REPORT UPDATE

Application No: LU/94/17/OUT

Recommendation Report for Outline Consent

PROPOSAL: Outline application with all matters reserved for residential re-development comprising of 10 No. dwellings & associated works (resubmission following LU/327/16/OUT).

Proposed foul water drainage

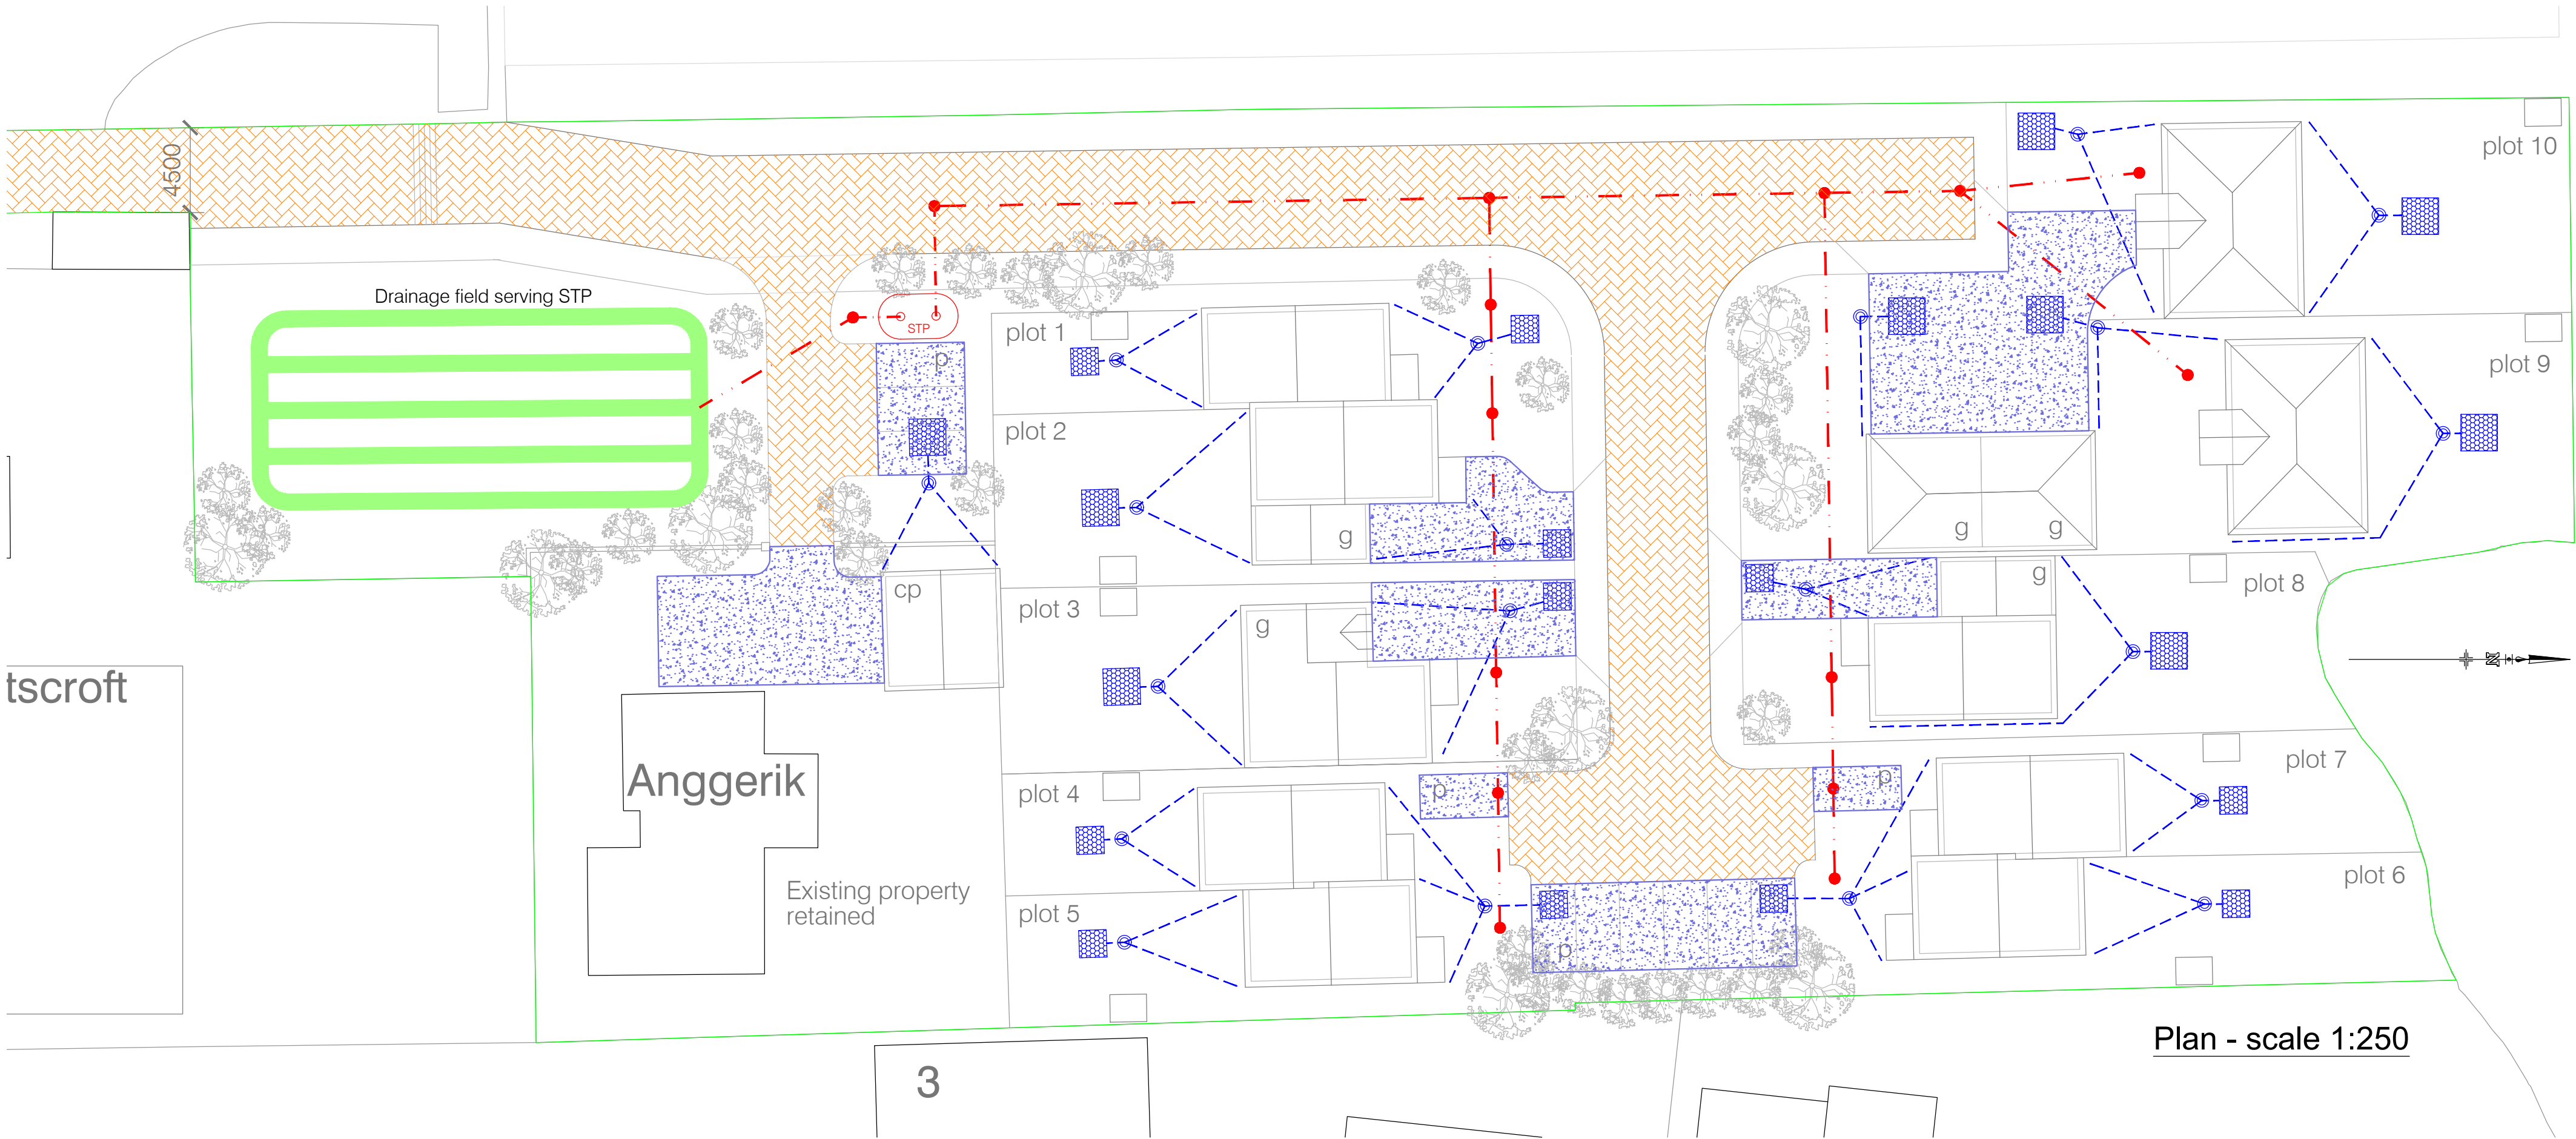
We note that this development proposes to dispose of foul drainage through an on-site package treatment plant. Considering the current location of the mains sewer network and the size of this development this approach may be appropriate, however, we are aware that the larger development at Toddington Nurseries is currently being built out in close proximity to this site. When occupied the development will provide a public mains sewer network nearer to this site which would make a connection here more appropriate.

We consider that through the reserved matters application further consideration should be given to the proposed method of foul drainage and where possible seek to connect to the public foul sewer.

The development hereby permitted shall not be commenced until such time as a scheme to dispose of foul drainage has been submitted to, and approved in writing by, the local planning authority. The scheme shall be implemented as approved.
